From: Bernadette Owens
Sent: 01 September 2021 09:35
To: DC Support
Subject: FW: 21/02467/F - neighbouring authority consultation

From: Samuel Dix <Samuel.Dix@westnorthants.gov.uk>
Sent: 01 September 2021 09:33
To: Bernadette Owens <Bernadette.Owens@Cherwell-DC.gov.uk>
Subject: RE: 21/02467/F - neighbouring authority consultation

Further to our correspondence below, following discussion with WNC's Cabinet Member for Strategic Planning and local members, WNC as a neighbouring Local Planning Authority wishes to amend its comments and object to application 21/02467/F for the following reasons:

**Zone of Visual Influence Proposed Hotel & Office Block (Landform)**

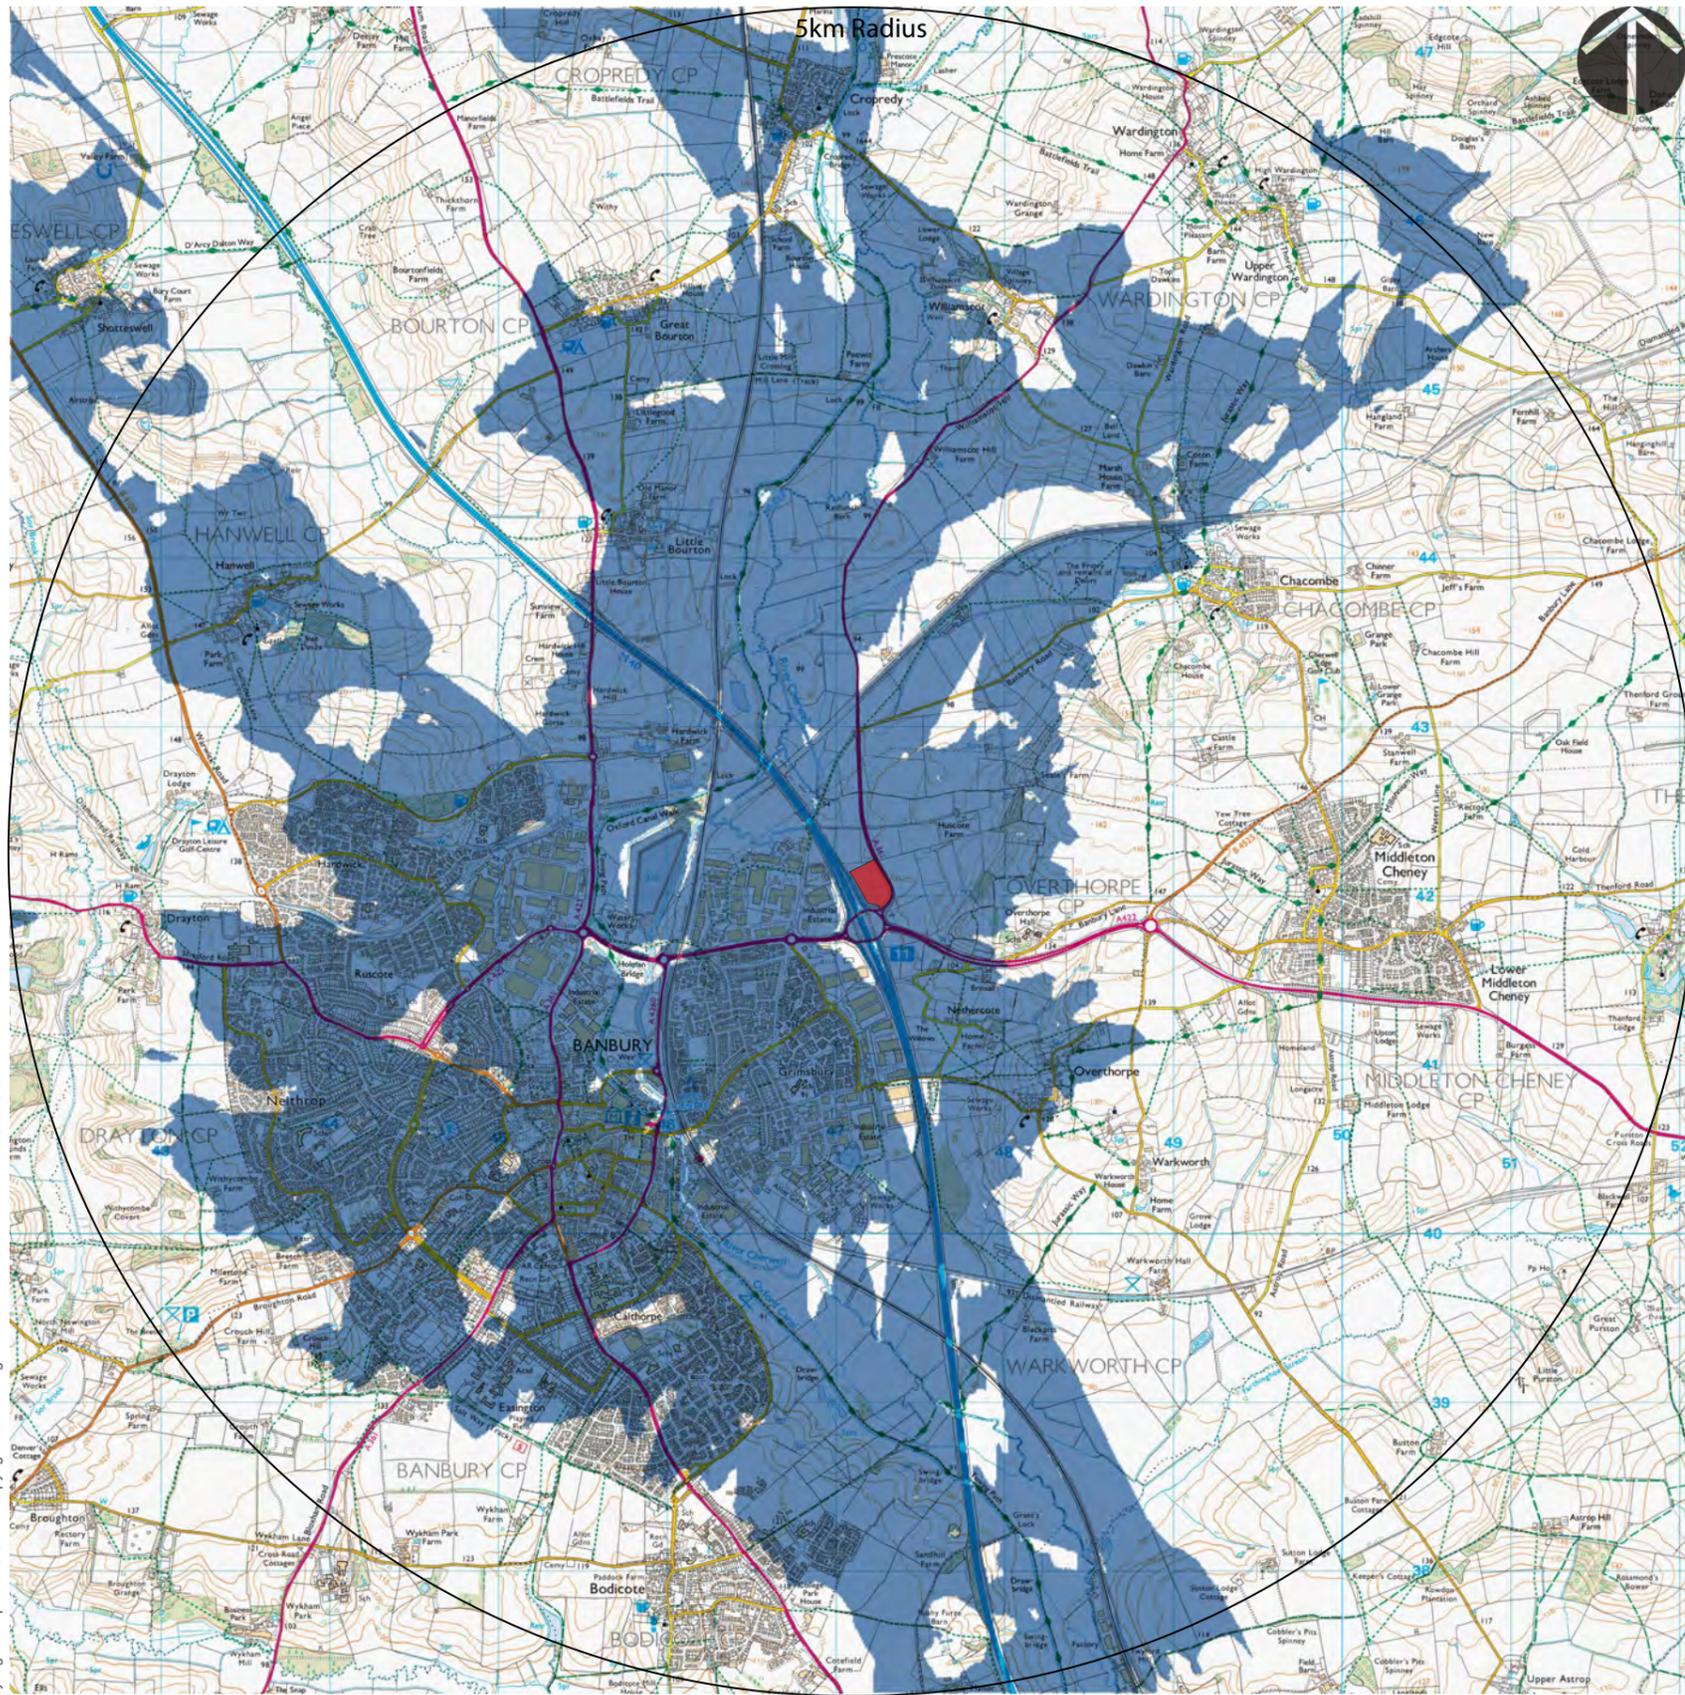
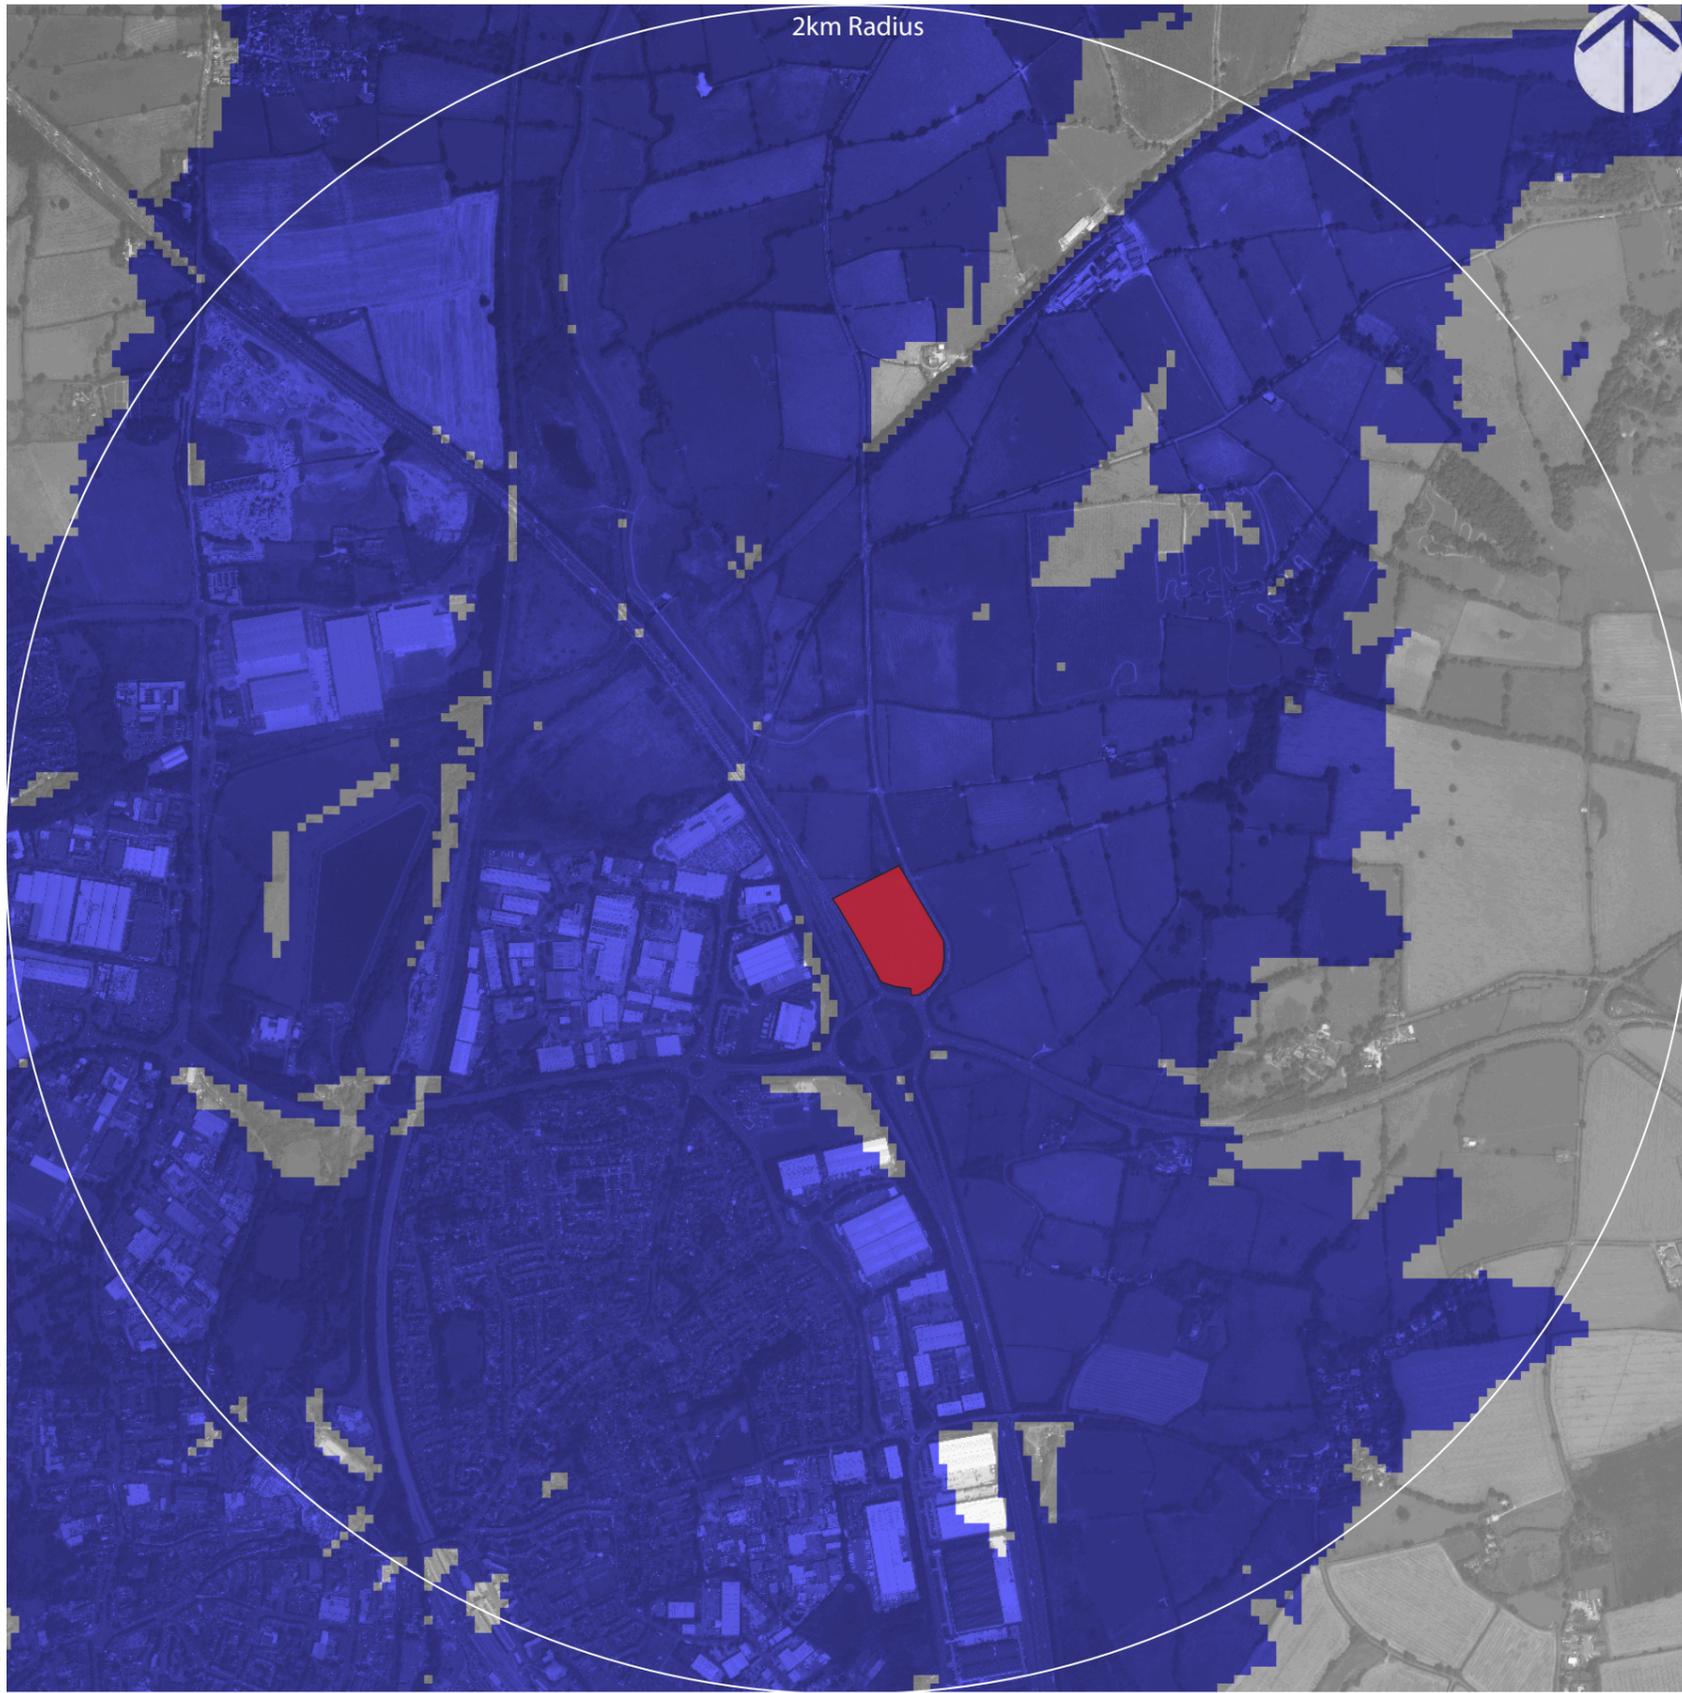
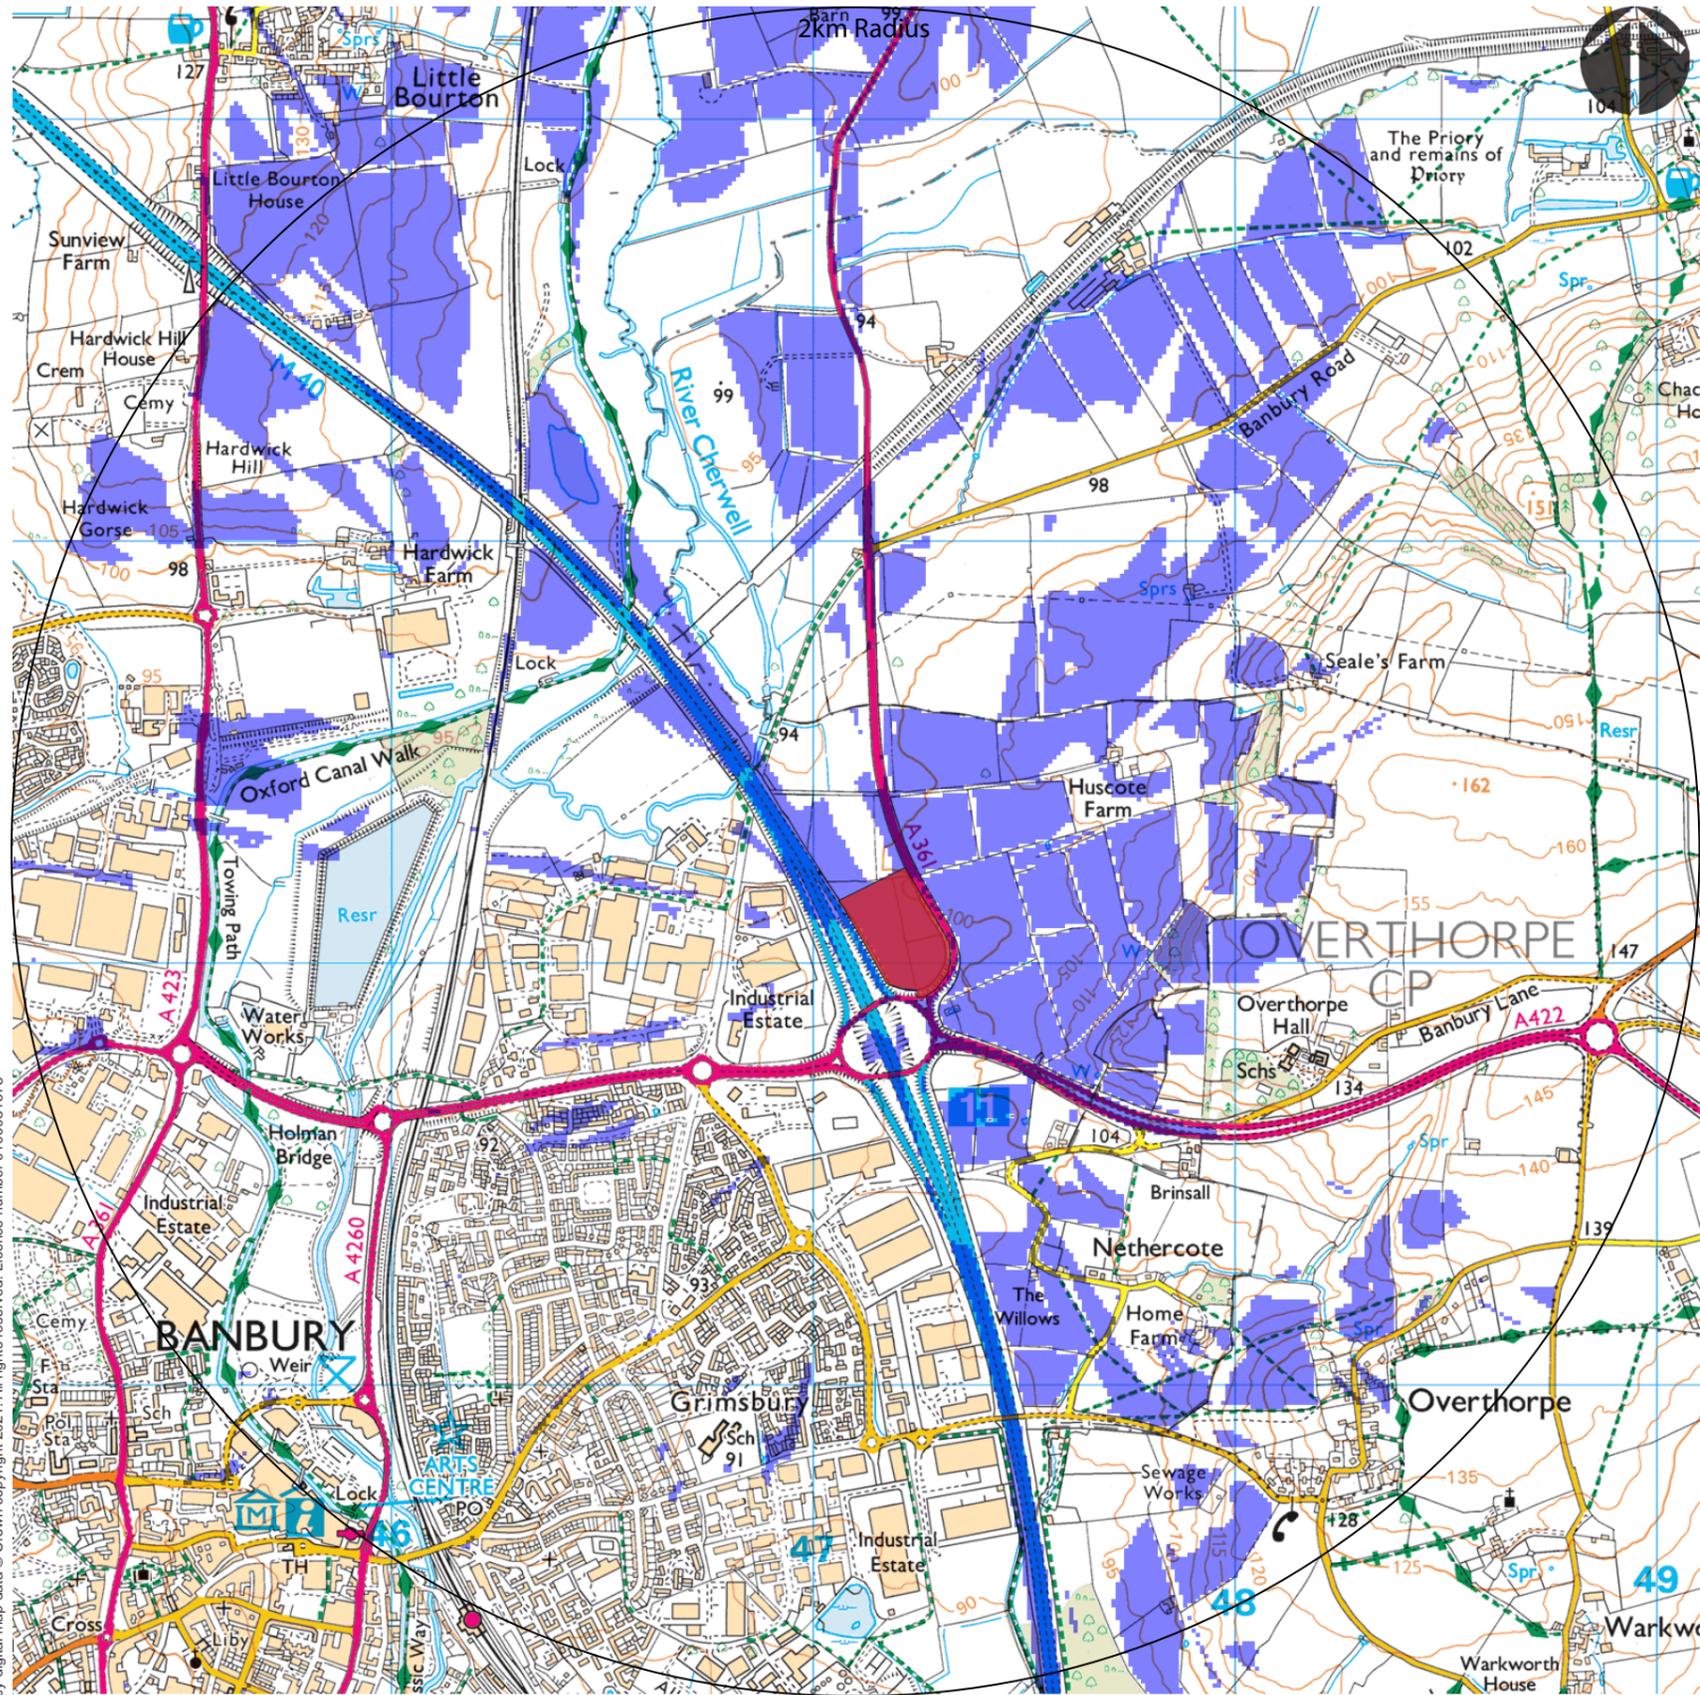
It is accepted that the site is allocated for development and as such visibility from elevated ground in West Northamptonshire in the directions of Overthorpe and Middleton Cheney is to some degree inevitable. This is a matter increasingly apparent with ongoing construction to the north of the site. However, WNC consider that the proposed hotel in particular, being situated so prominently at the southern end of the site and being of uninspiring design does not represent an appropriate "gateway" to/from Cherwell/West Northamptonshire. Following the adoption of the South Northamptonshire Part 2 Local Plan, the previous Important Local Gap between Middleton Cheney and Banbury no longer applies but there is still the need to develop the site in an appropriate manner. WNC is concerned that a standard or formulaic design for such a prominent building is not consistent with the new Framework's imperative to create high-quality and beautiful buildings and places.
